# Summary of Comments on 2111-086-SUB1-PLANS\_review.pdf

Author: Building Review (gareth.reece@mercergov.org) Subject: Comment Date: 2/14/2022 12:28:42 PM

SHEET No.:
A4.0

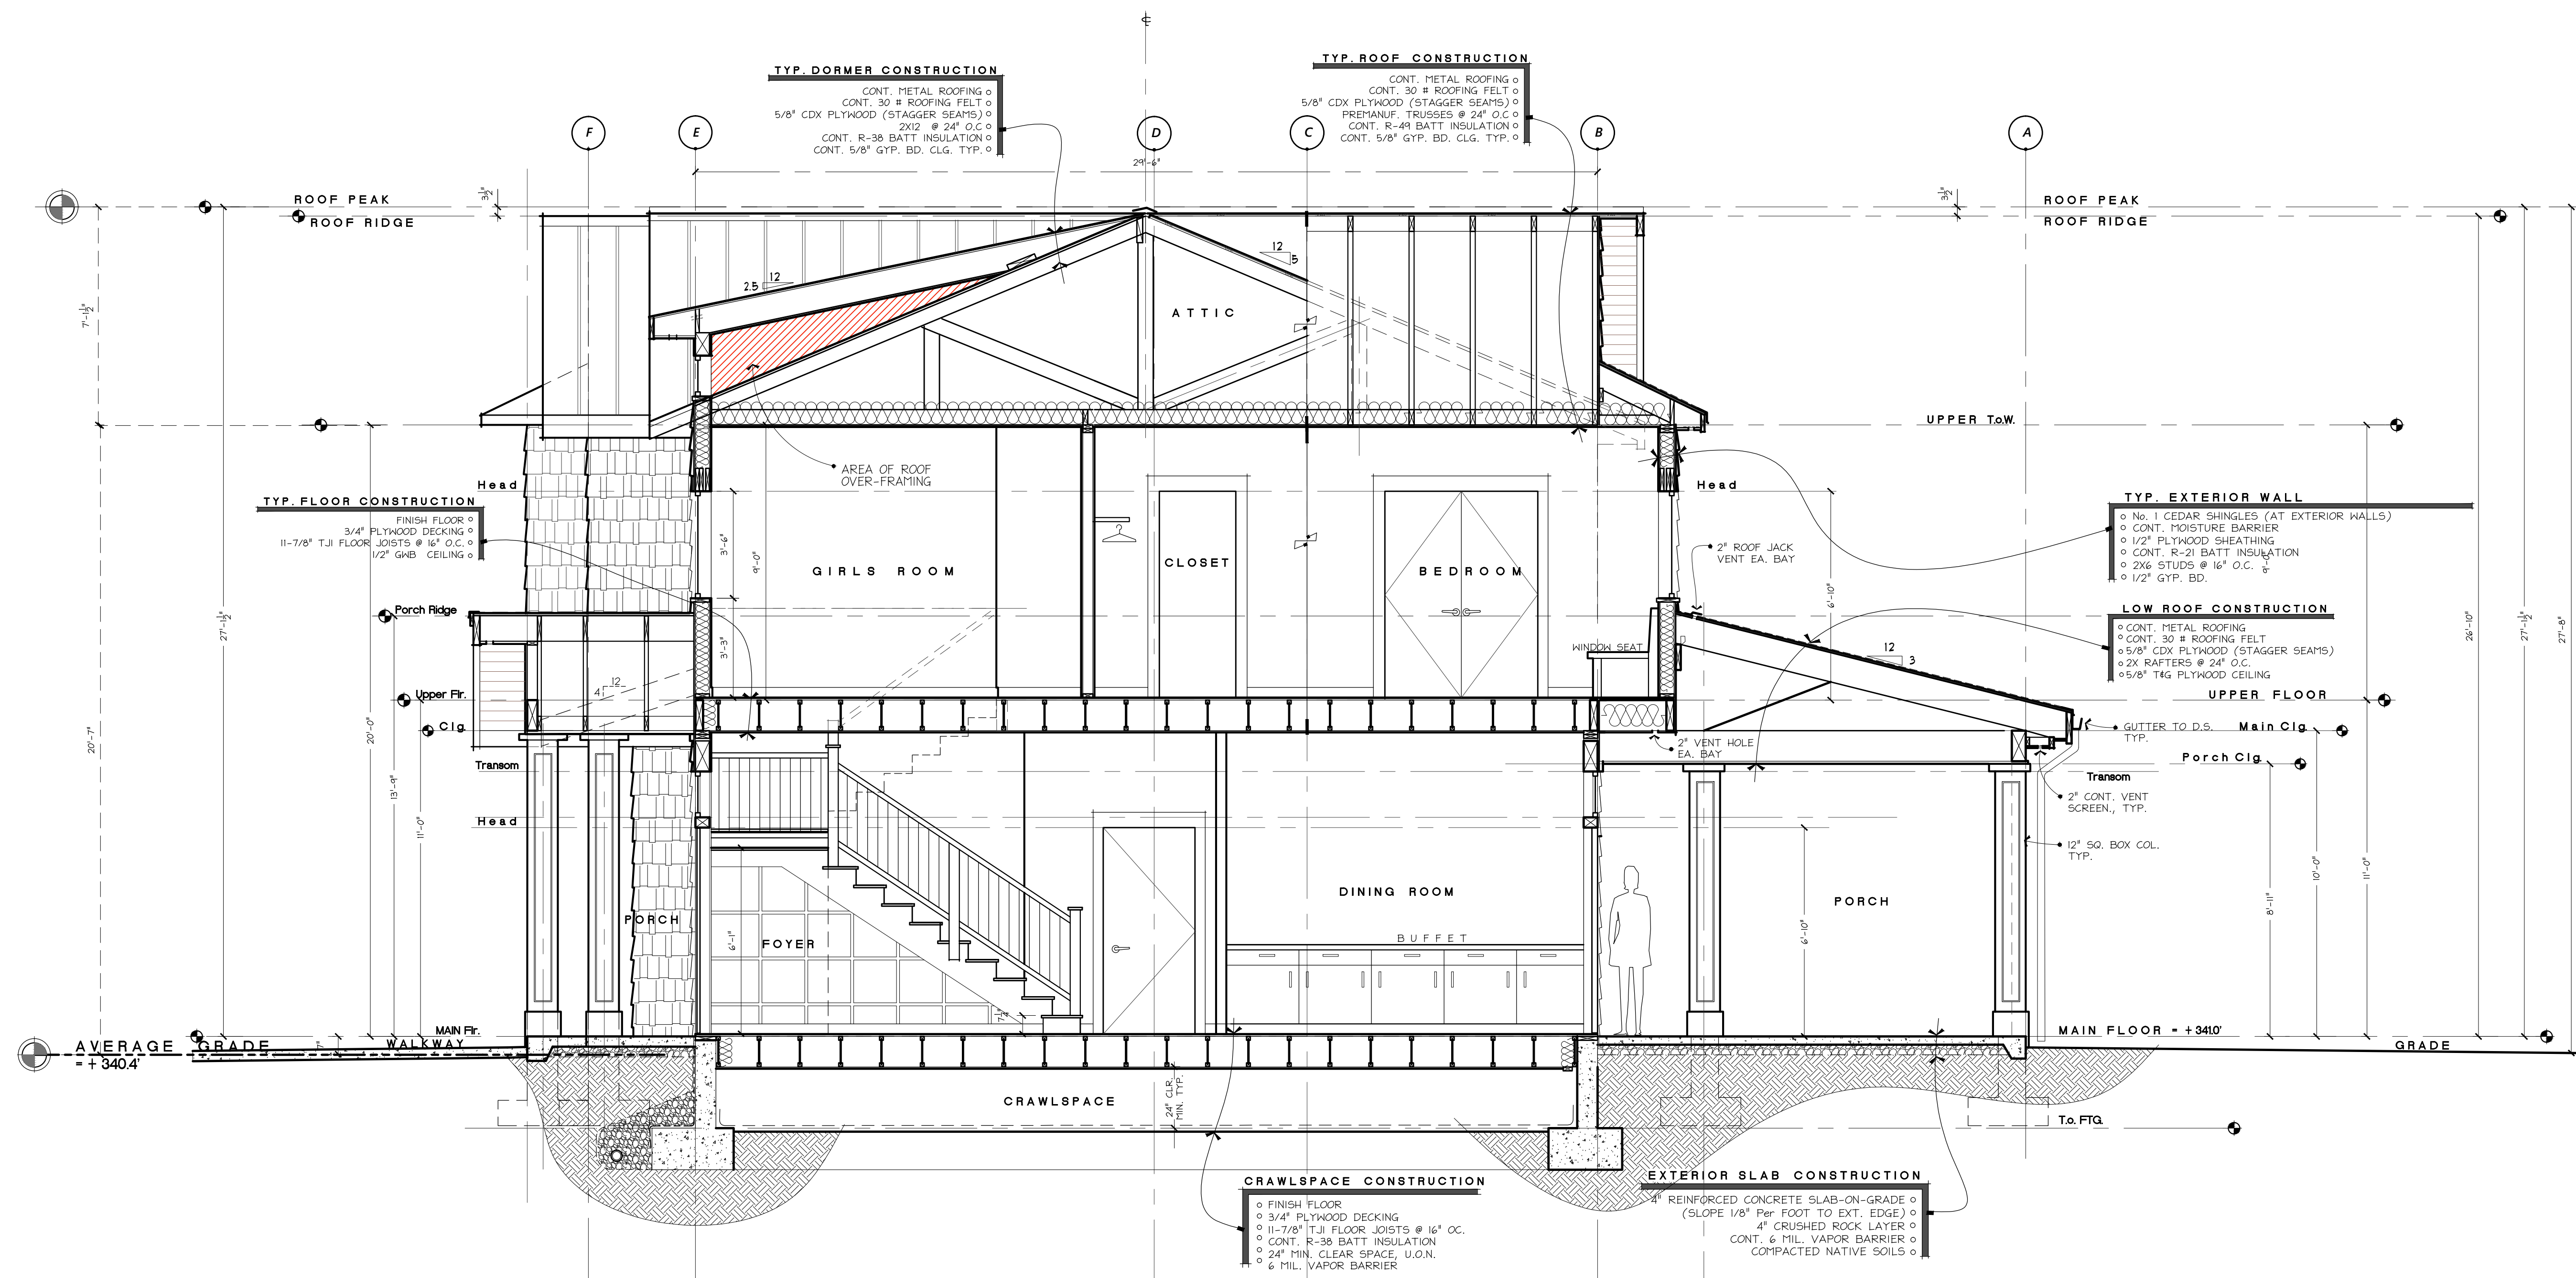
Roof truss construction and in particular the center roof has long spans which will result in live load deflections on the roof. Provide details for interior wall connections to allow for displacement without damage to finishes.

Author: Mark Myers, PE (myengineer@centurytel.net) Subject: Sticky Note Date: 2/15/2022 12:33:07 PM  
All trusses on this project are less than 30ft spans, exceed 4/12 pitch and have raised heels at the bearing walls. Excessive live load deflection is not typical for these conditions. Determining best practices for installation of cosmetic finishes is the responsibility of the contractor and their GWB sub-contractor.

FOUNDATION/FLOOR FRAMING PLAN

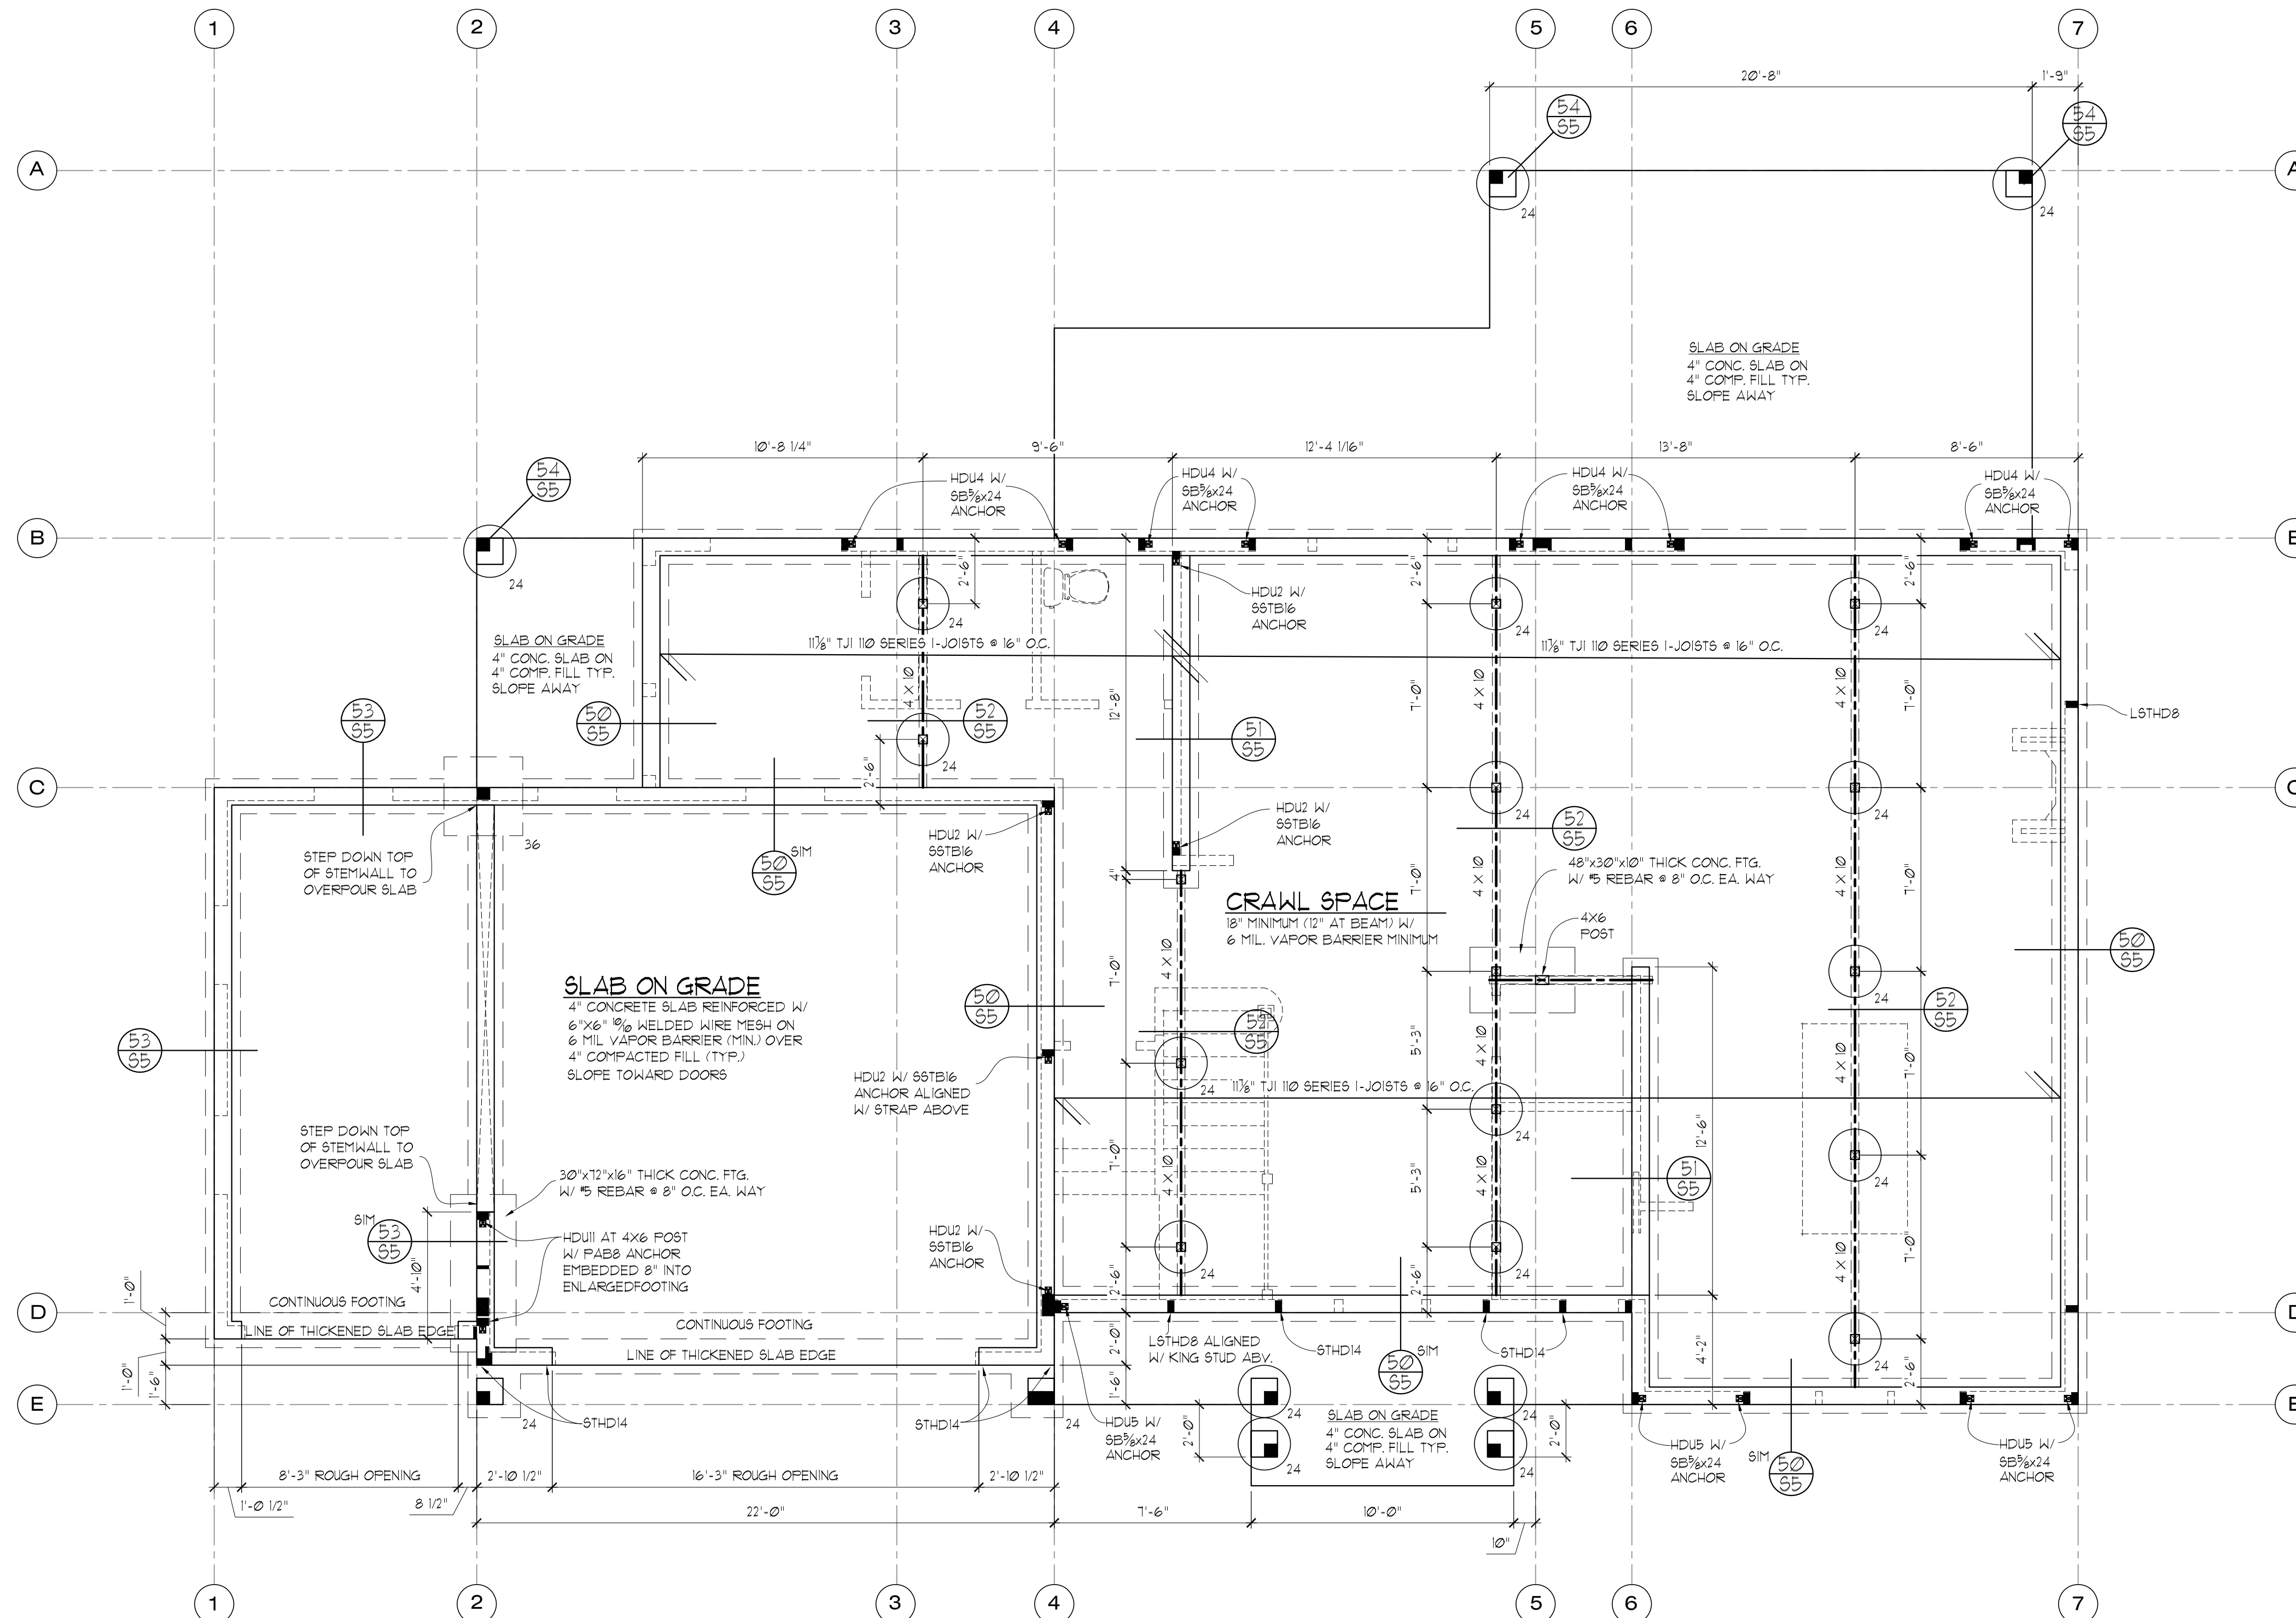
Provide framing details for landing and stair construction clarifying where point loads from landing construction might fall on the floor system.

The overframing for the landing will not impose significant point loads on the supporting Main floor joists. However, we have added an LSL joist to help transfer the load from the LSL at the top of the stair where it bears on the closet wall.

Provide details and locations for crawlspace ventilation. From foundation details and building section it appears that wells may be necessary for crawlspace vents?

Vent locations have been indicated on plans and a note specifying blockouts at slabs has been added as well.

💬 Author: Building Review (gareth.reece@mercergov.org) Subject: Comment Date: 2/14/2022 1:36:09 PM  
Clarify the joist size for this span

↩️ Author: Mark Myers, PE (myengineer@centurytel.net) Subject: Sticky Note Date: 2/15/2022 12:27:54 PM  
The plan clearly indicates the use of 11-7/8" TJI 230 I-joists @ 16" o.c. spanning from grid 5 over the interior wall to the Garage wall at Grid 4 and to the rim/beam at or near Grid 2. For increased clarity we have moved the joist callout to the west side of the interior wall.

S4	DATE:	10-2-2021
	INITI:	MM
PROJECT #:	2394

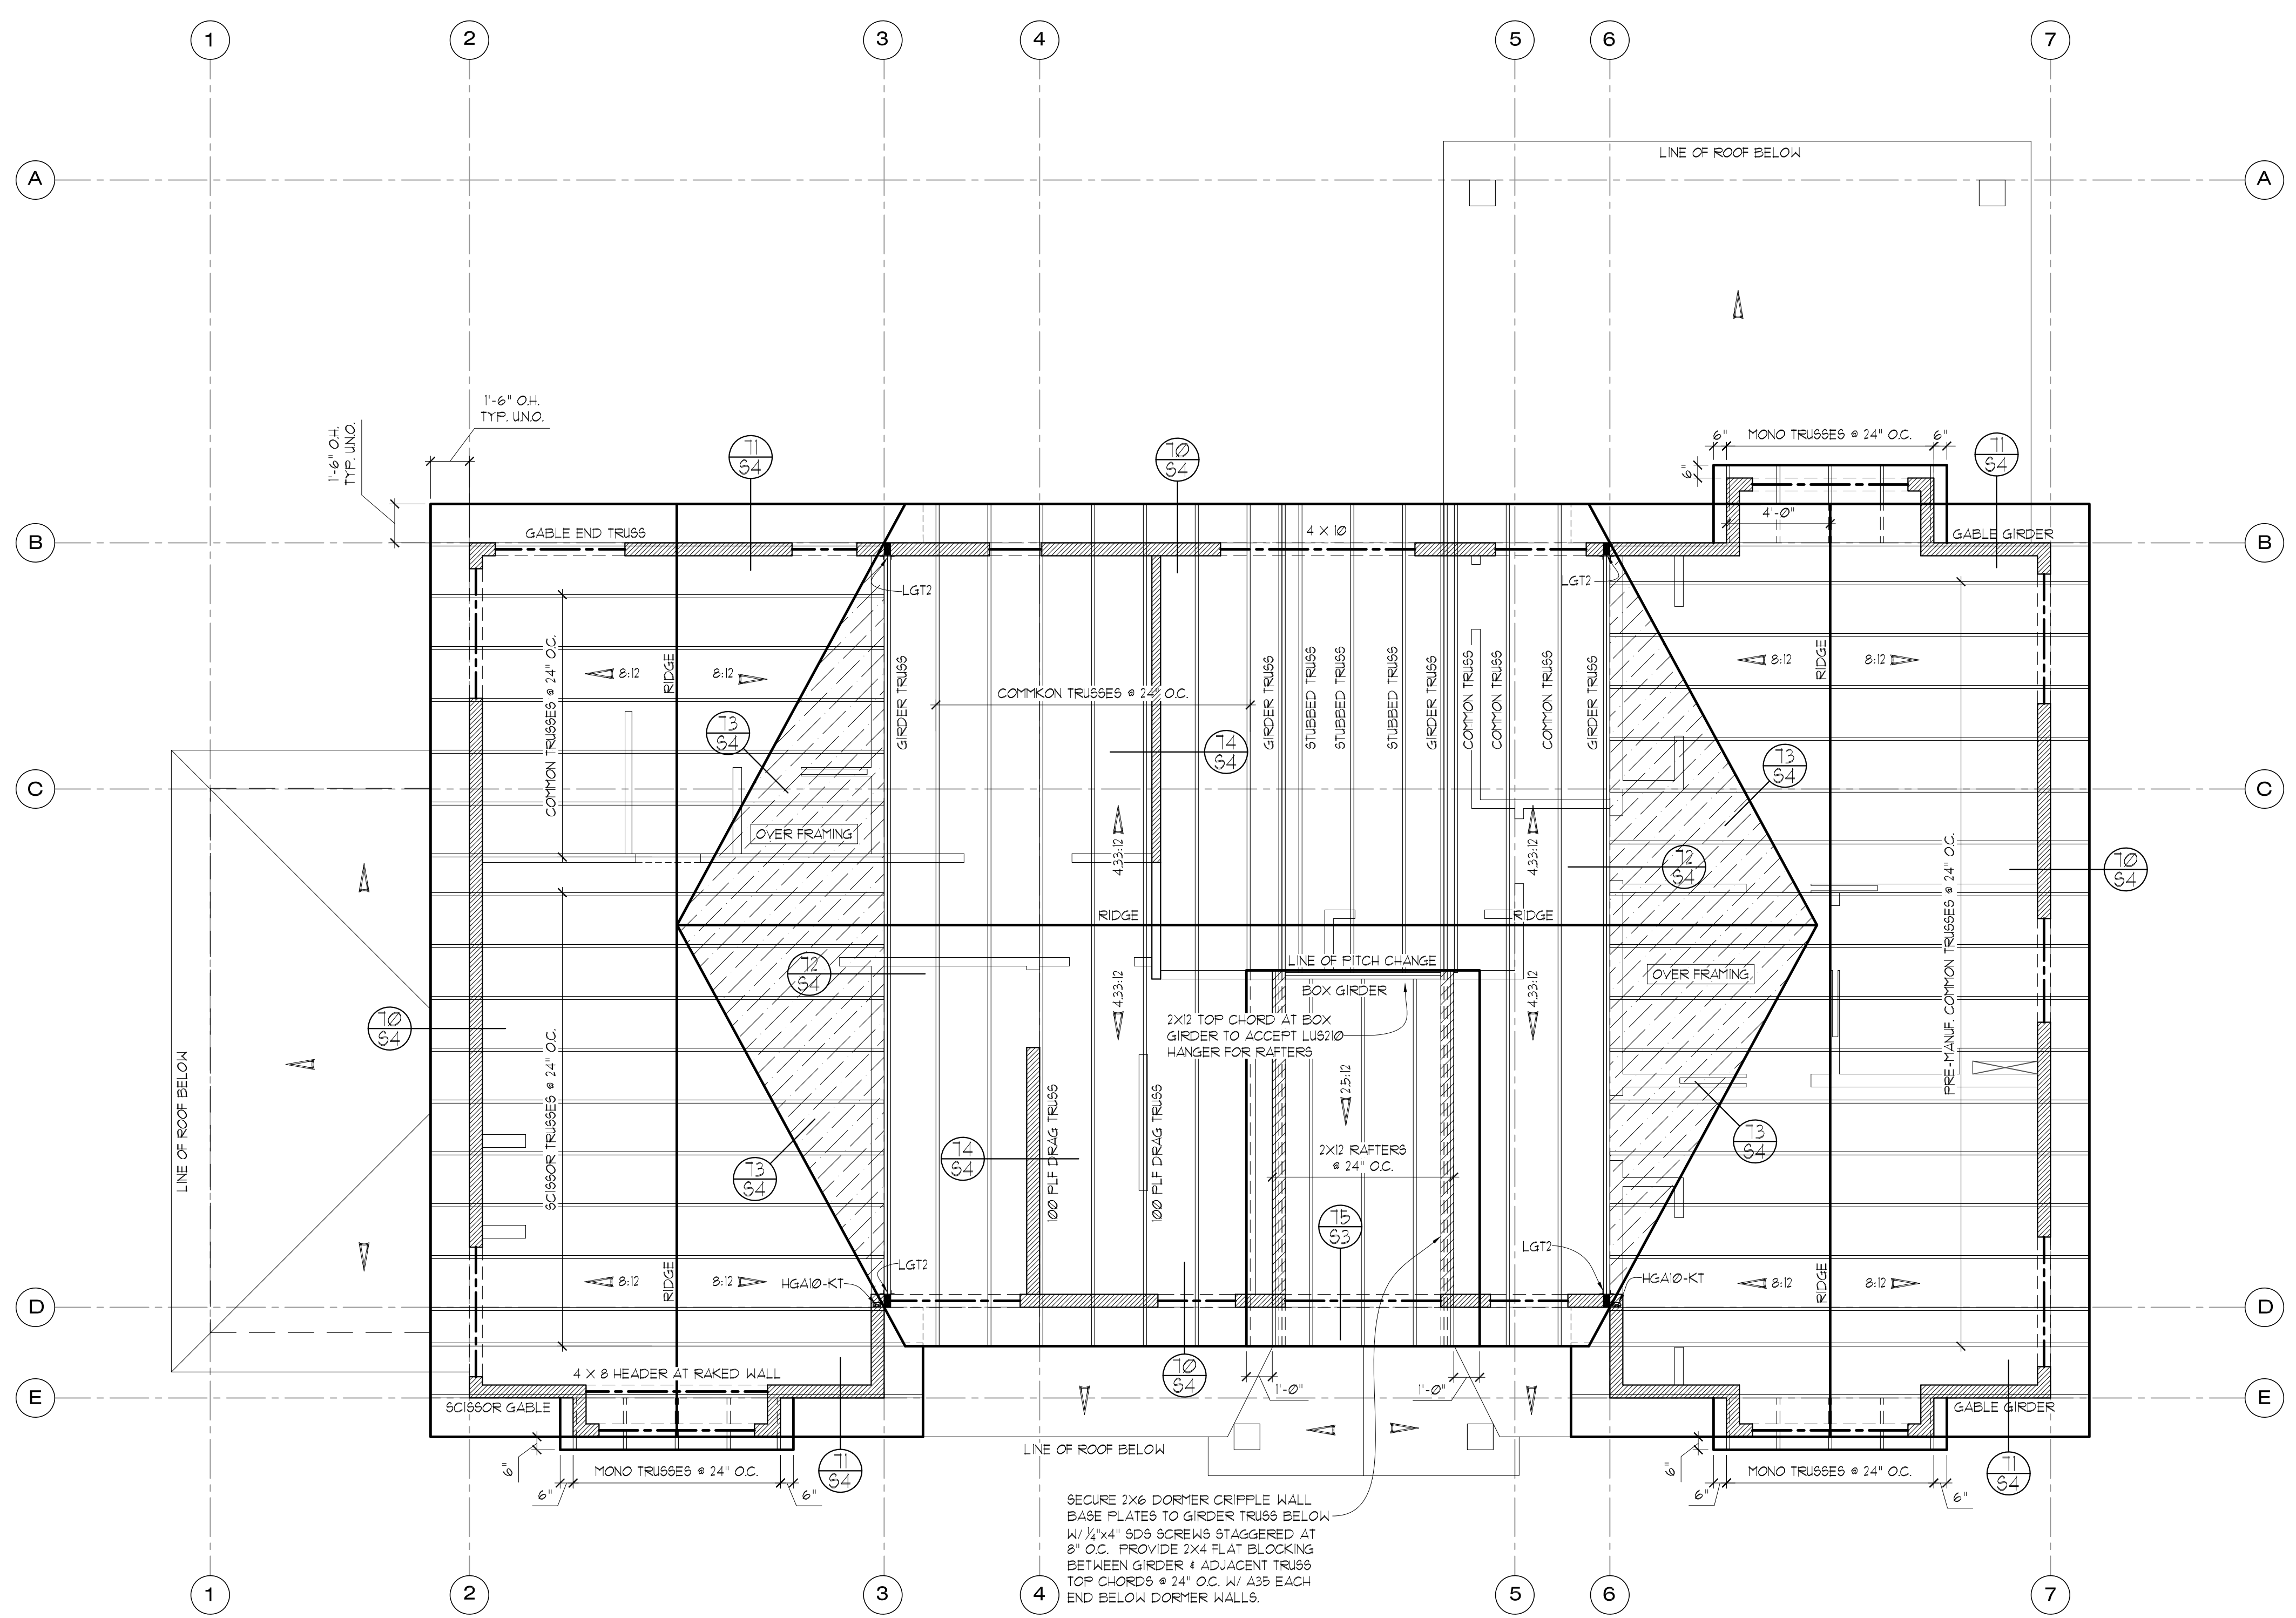
Clarify how panel edge nailing is provided for shear transfer from the roof diaphragm to the blocking.

Author: Mark Myers, PE (myengineer@centurytel.net) Subject: Sticky Note Date: 2/15/2022 9:17:25 AM  
We have revised the detail
